Development Management
Lincolnshire County Council
County Offices
Newland
Lincoln LN1 1YL
Tel: 01522 782070
developmentmanagement@lincolnshire.gov.uk

Application Ref: H23-0201-26

Proposal: **Change of use of former telephone exchange to residential dwelling with new flexible outdoor entertainment space to the rear**

Location: **Former Telephone Exchange, Common Road, Whaplode Drove, Spalding, PE12 0UF**

Proposed Block Plan
Scale 1:100

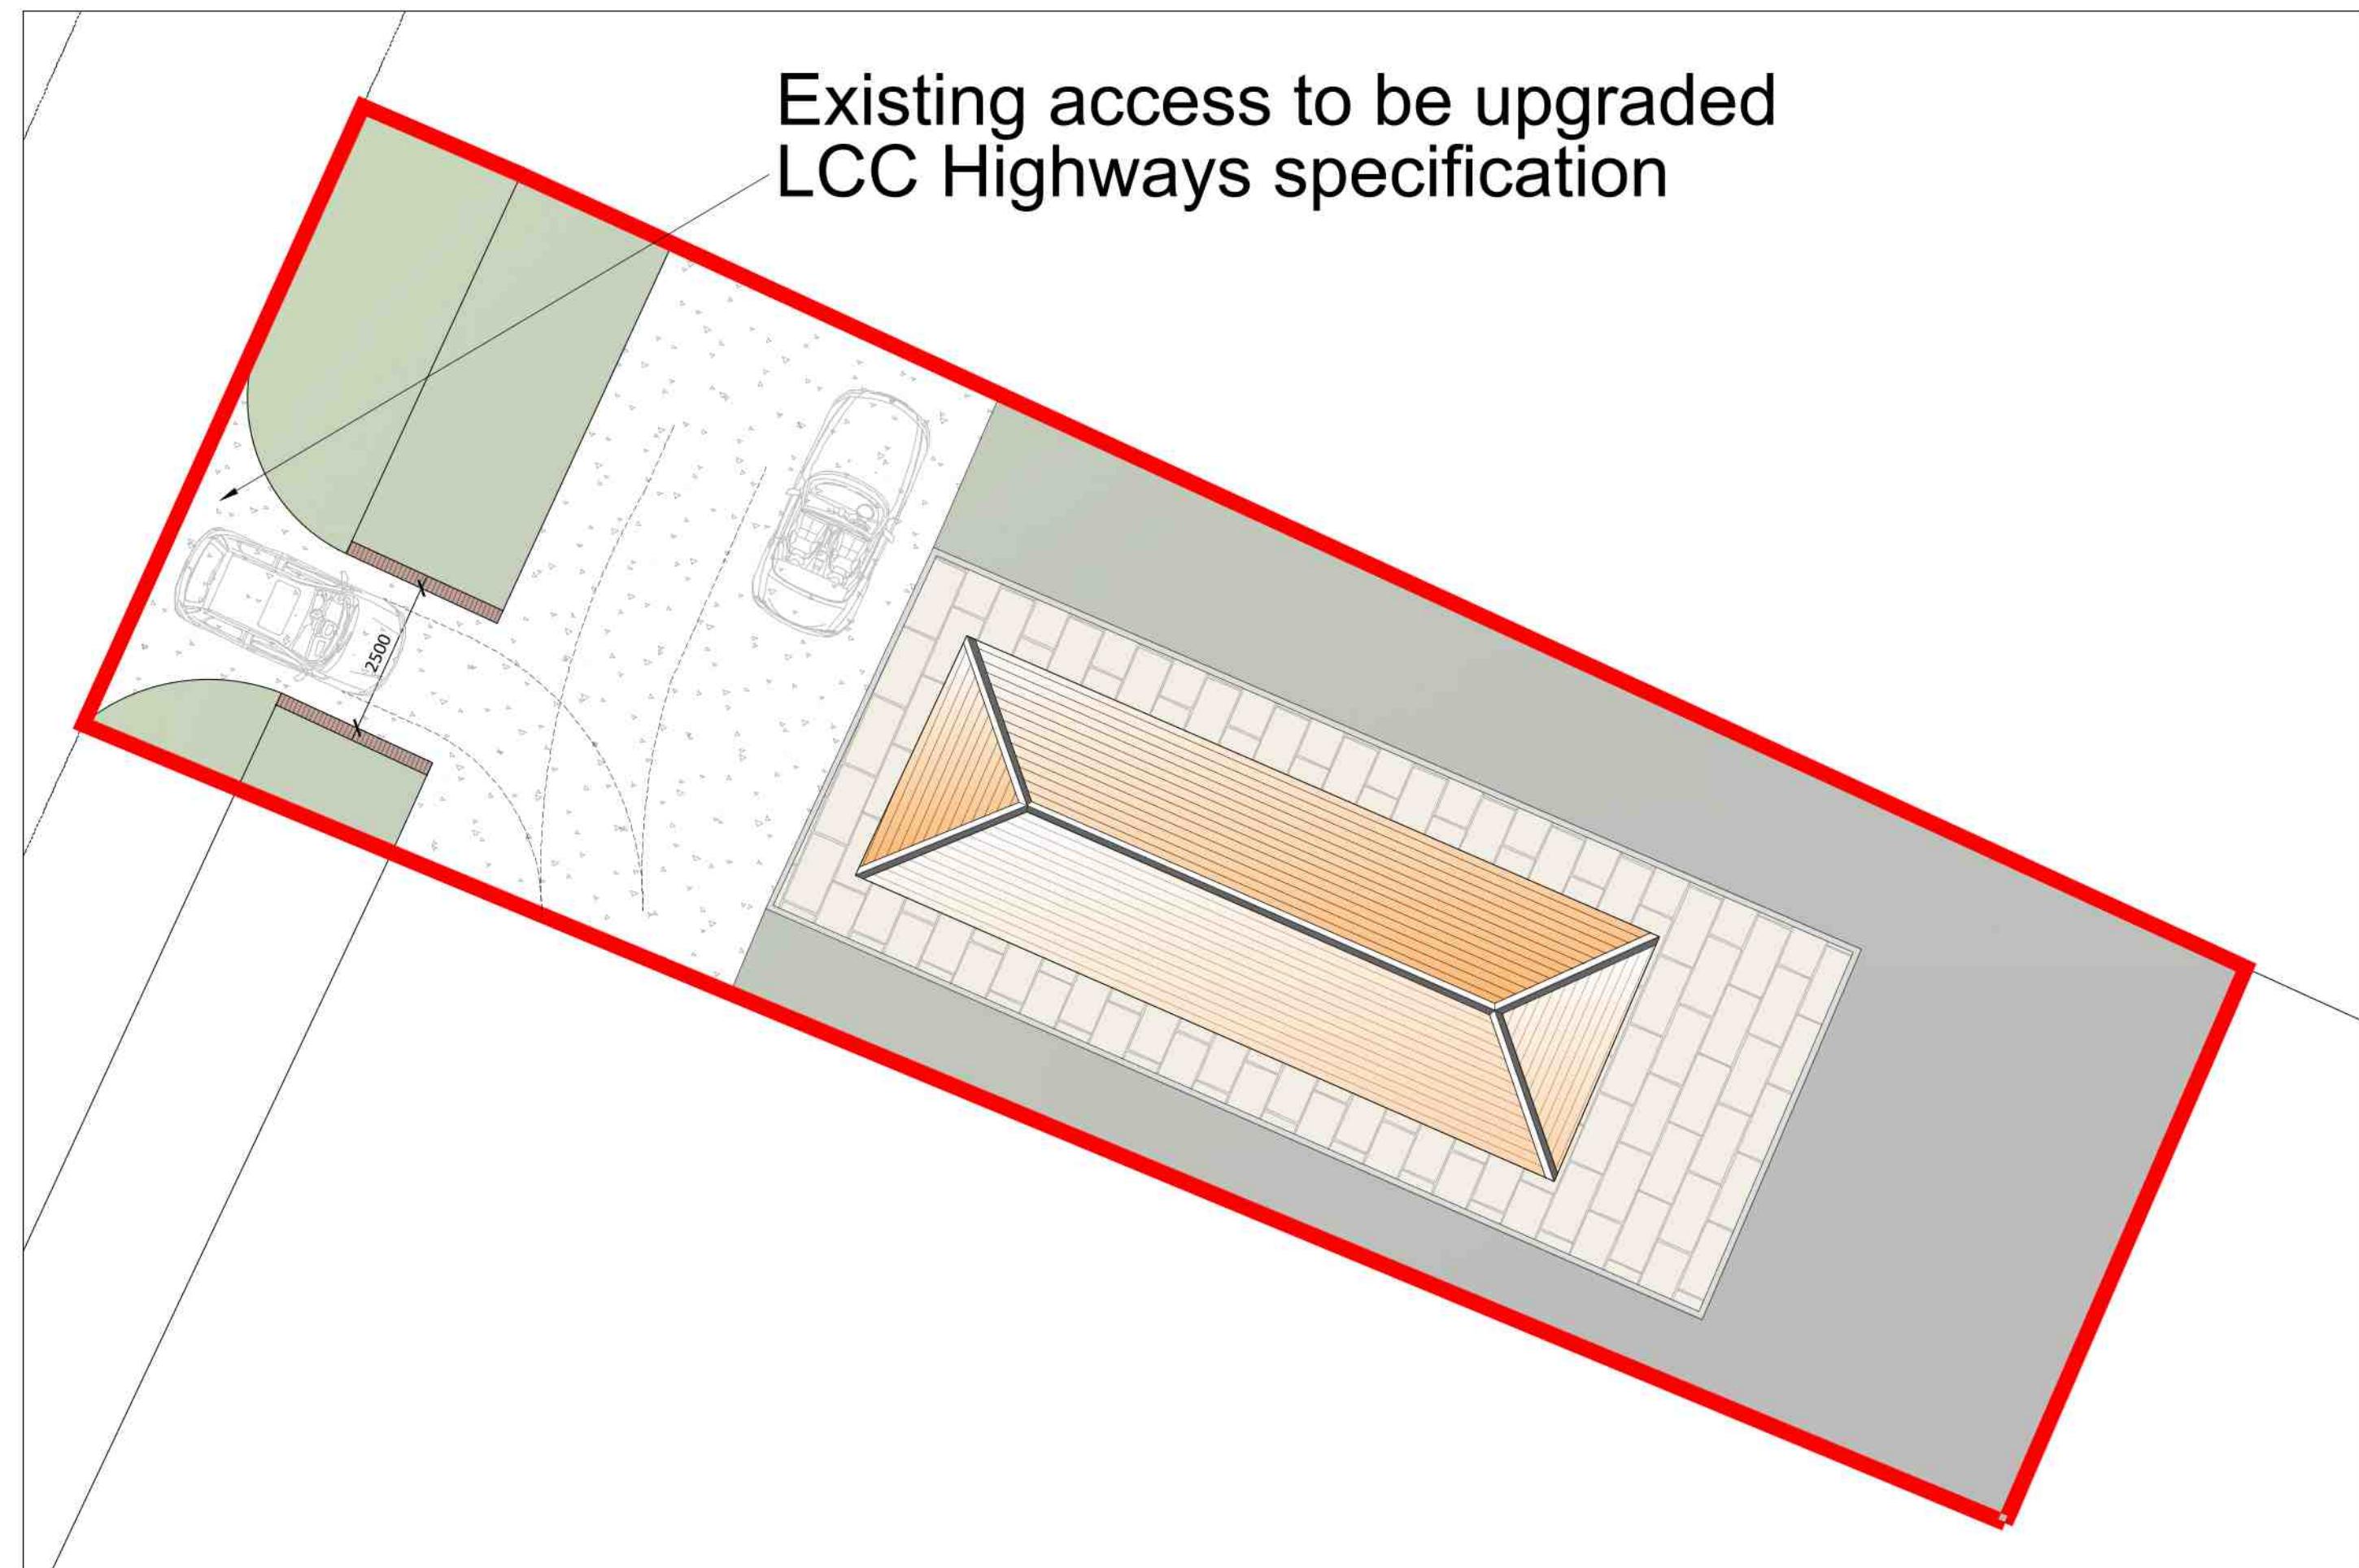
Measurements of the access, bridge, parking and turning area need to be detailed on the proposed site plan.

We would not allow the gravel to go up to the highway as this would be hazardous to the users of the public highway. The bridge is set back from the highway, and the access will need to be upgraded to Lincolnshire County Council Specification - a note should detail this on the proposed site plan.

Proposed Block Plan  
Scale 1:100

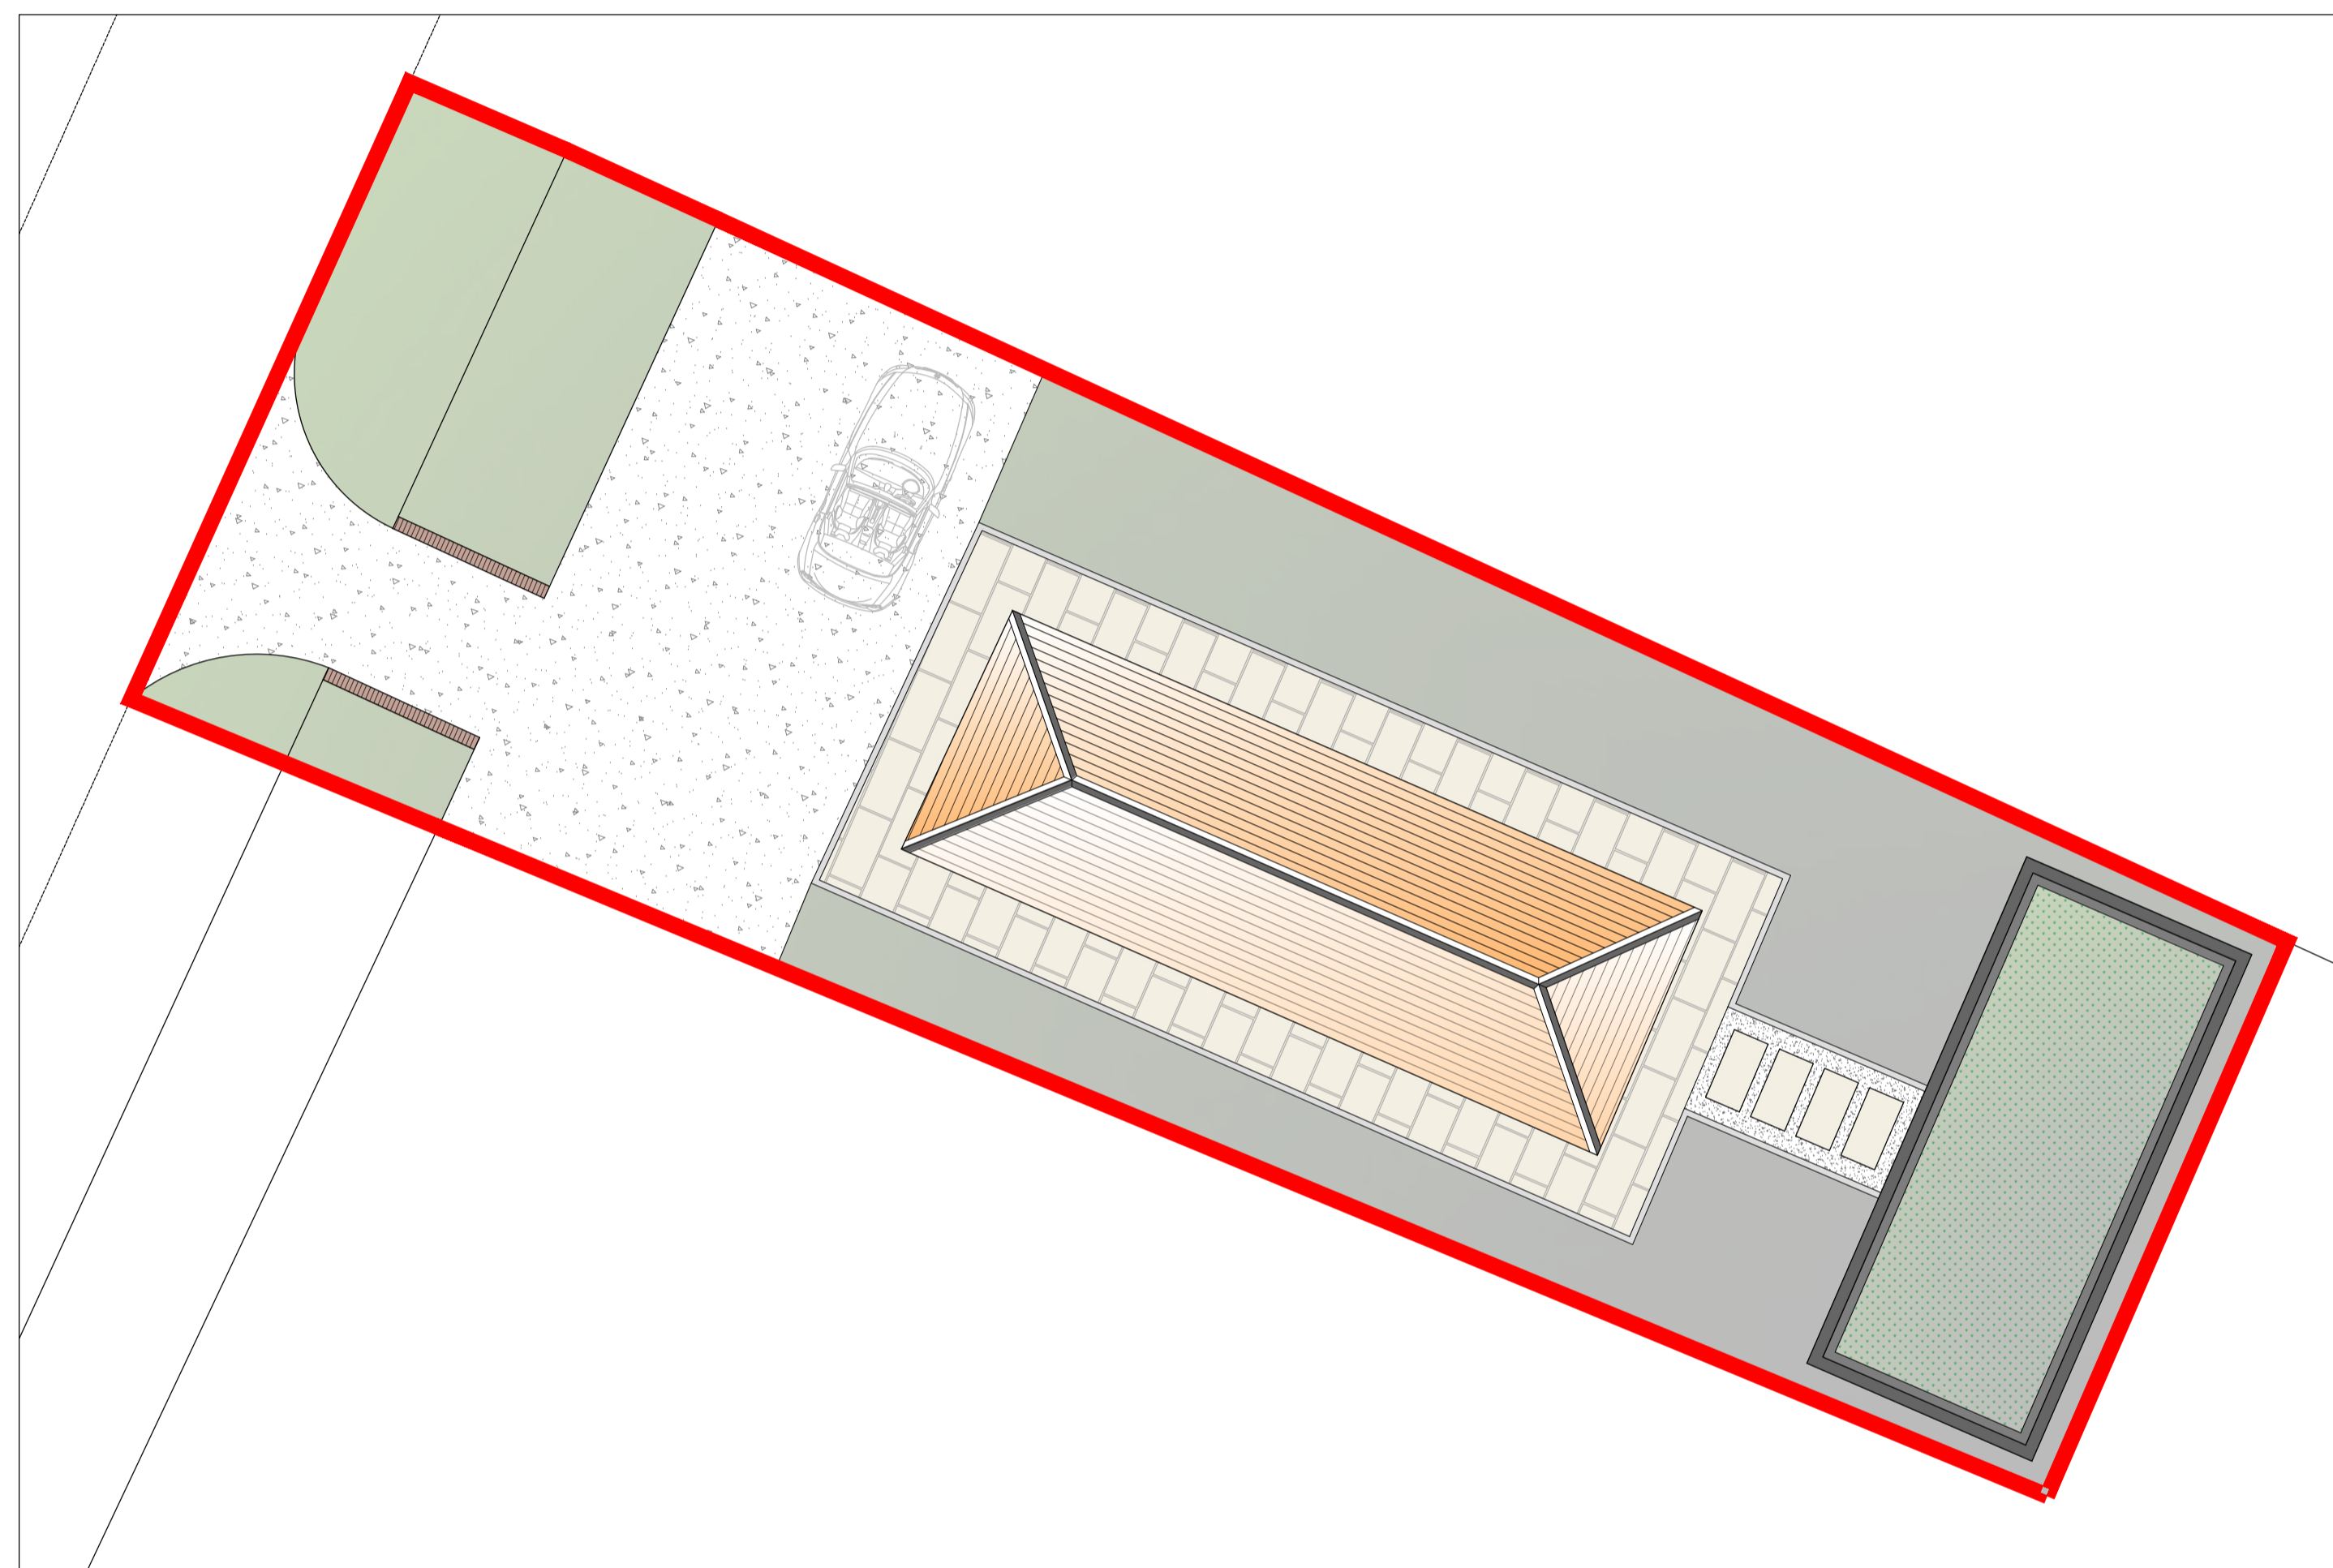
The Design & Access Statement refers to access via an existing bridged access over the watercourse - it is very overgrown on site, and you cannot see the condition of said bridge. Has this been investigated?
